## Health Precinct Stage 1

### DESIGN EXCELLENCE REVIEW PANEL

Update to Support State Significant Development Application

July 2017

BRUCE WILLIAMS PAVILION

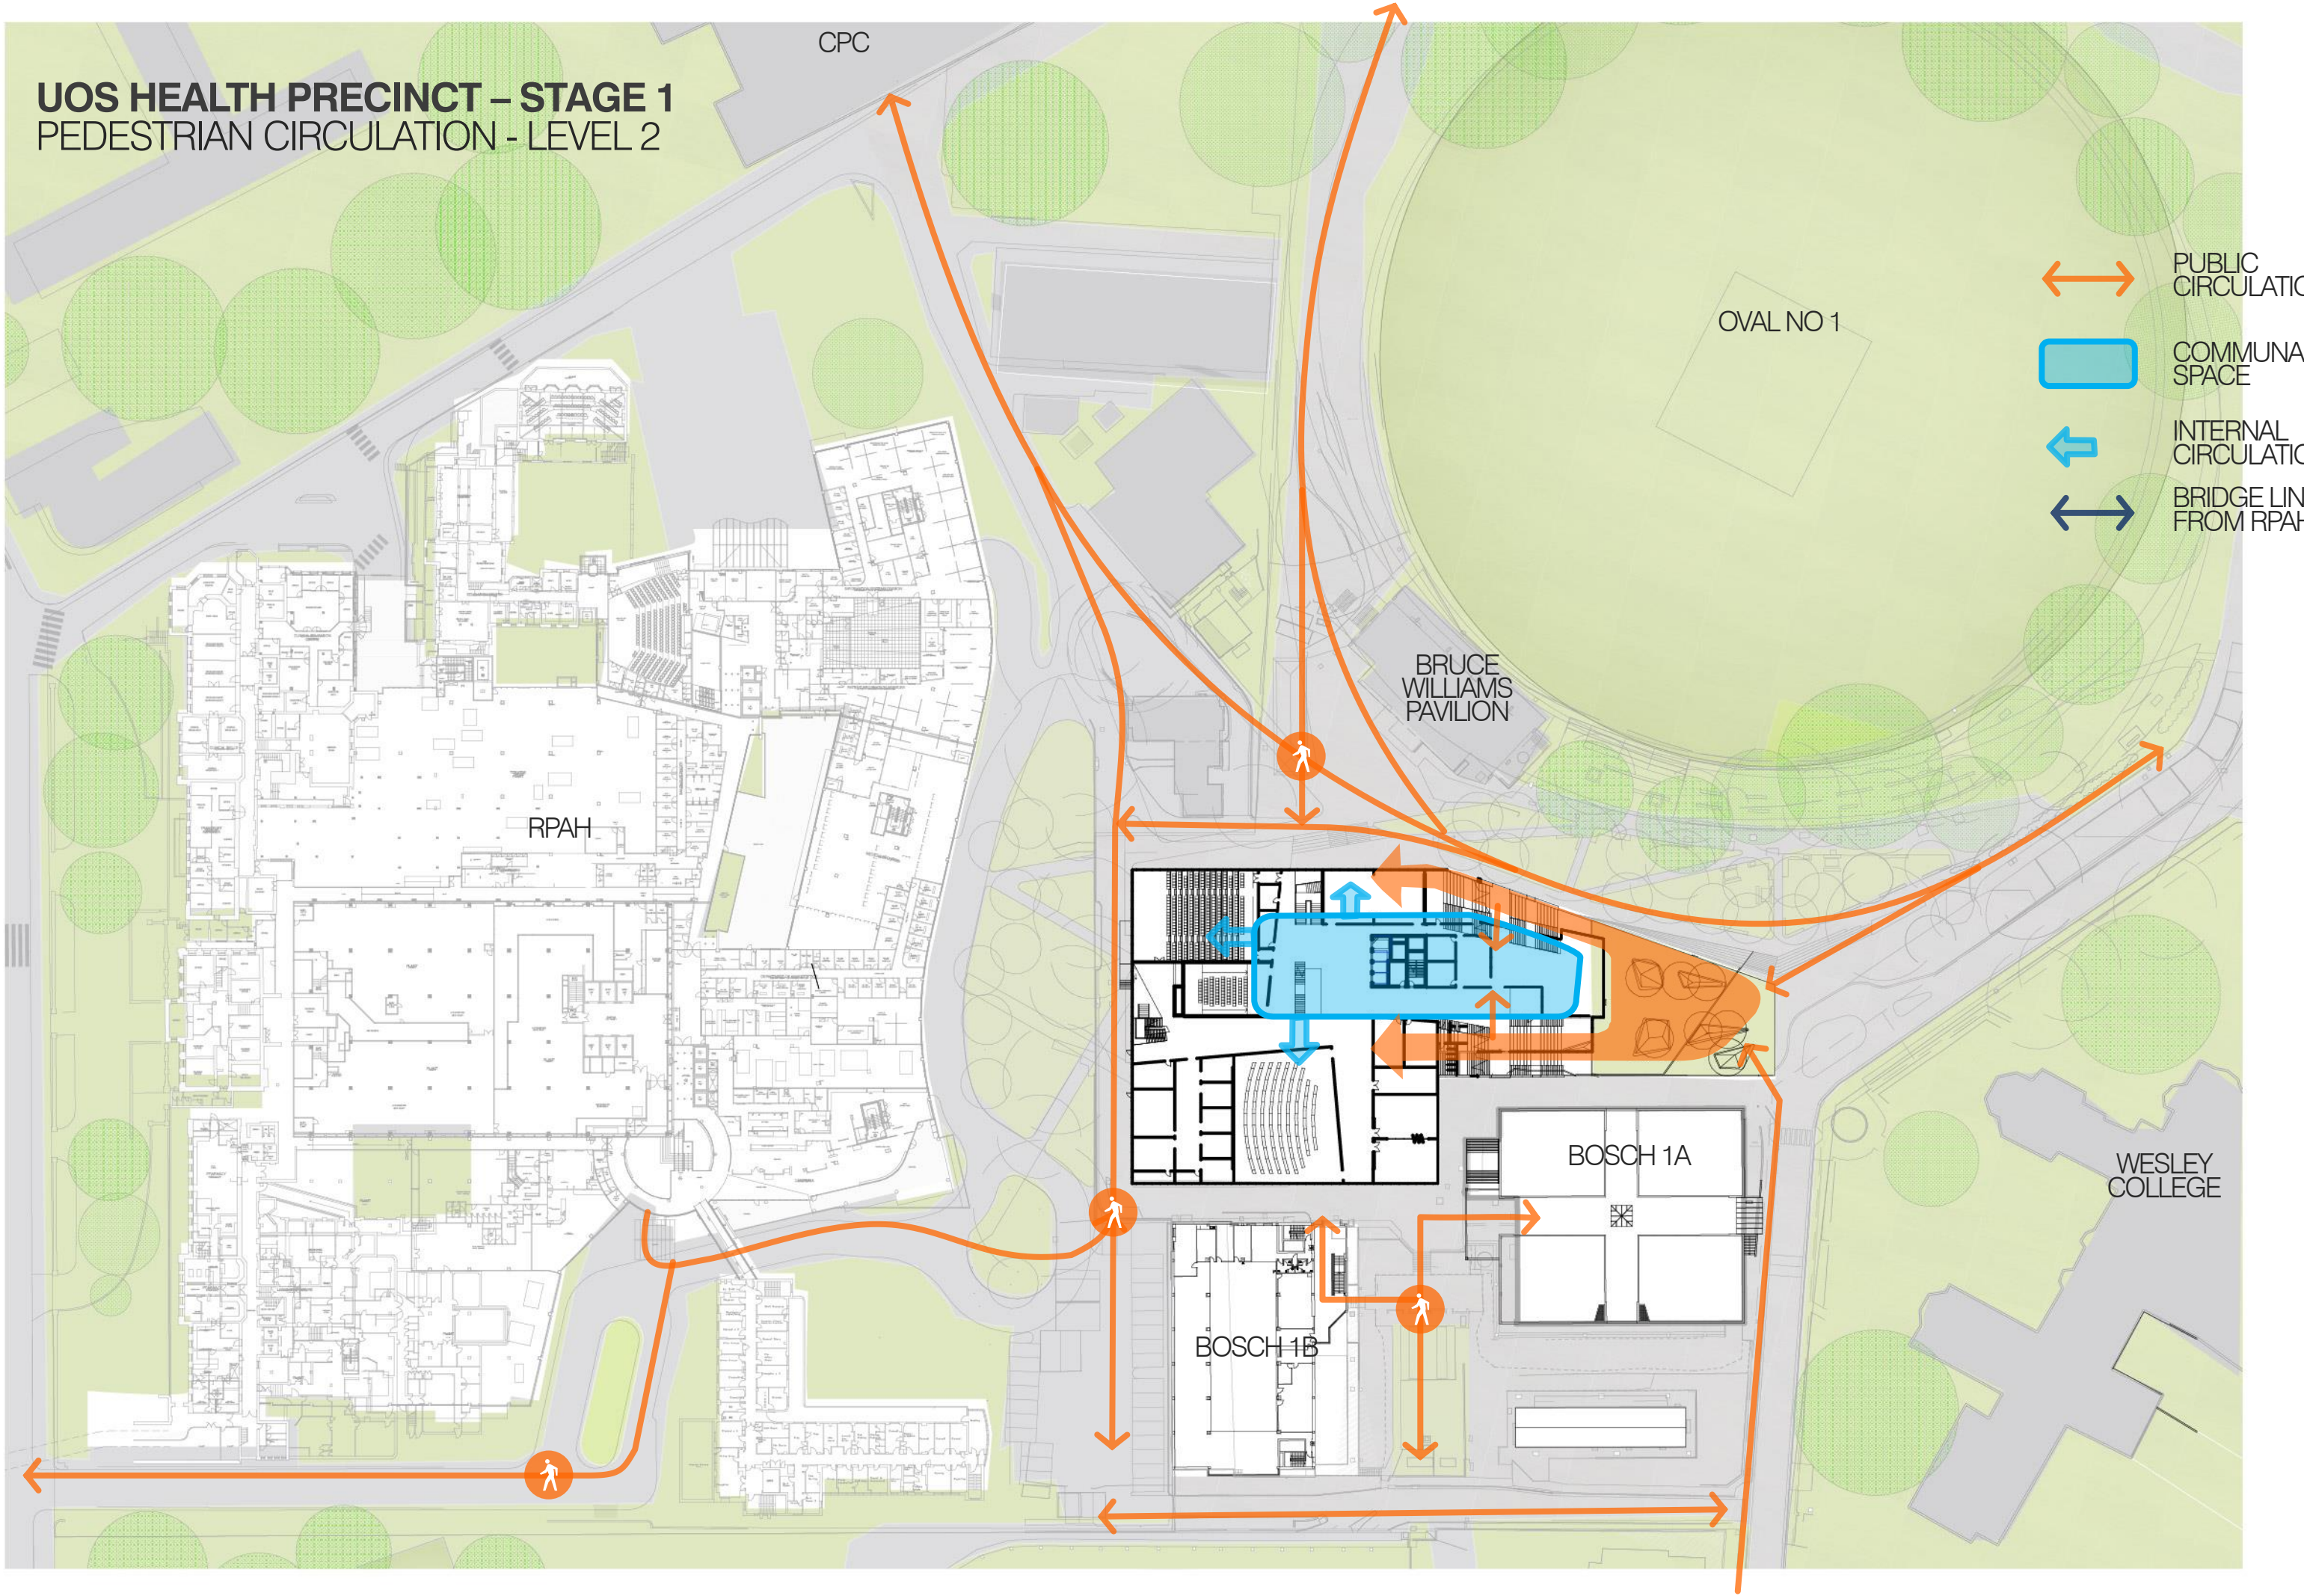
Ref	DCJ design excellence issue	Design refinement
1	Pedestrian flow studies would be useful to measure pedestrian use in peak periods to test for congestion	Flows were analysed and design modified to increase circulation corridors and stair widths
2	<p>Landscape solution should be reviewed in relation to the following:</p> <ul style="list-style-type: none"> <li>• consider a reductive approach to some of the elements eg water features</li> <li>• Review disposition of building elements below the main entry to enable soil depths that facilitate tree planting. Consider retention or relocation of the existing fig tree</li> <li>• Reconsider overland flow strategy and drainage edges</li> </ul>	<p>Landscape scheme has been significantly refined:</p> <ul style="list-style-type: none"> <li>• Water feature has been simplified with areas of water flow replaced with misters</li> <li>• Opportunities for deep soil planting and large trees at the entry have been significantly increased. Arborist advice in relation to the fig has confirmed that general condition including tree roots does not warrant retention.</li> <li>• Overland flow has been satisfactorily addressed with a clear strategy of capture, storage and release that utilises underground zones created by the demolition of the Blackburn building with inlets and outlets integrated with landscape areas.</li> </ul>
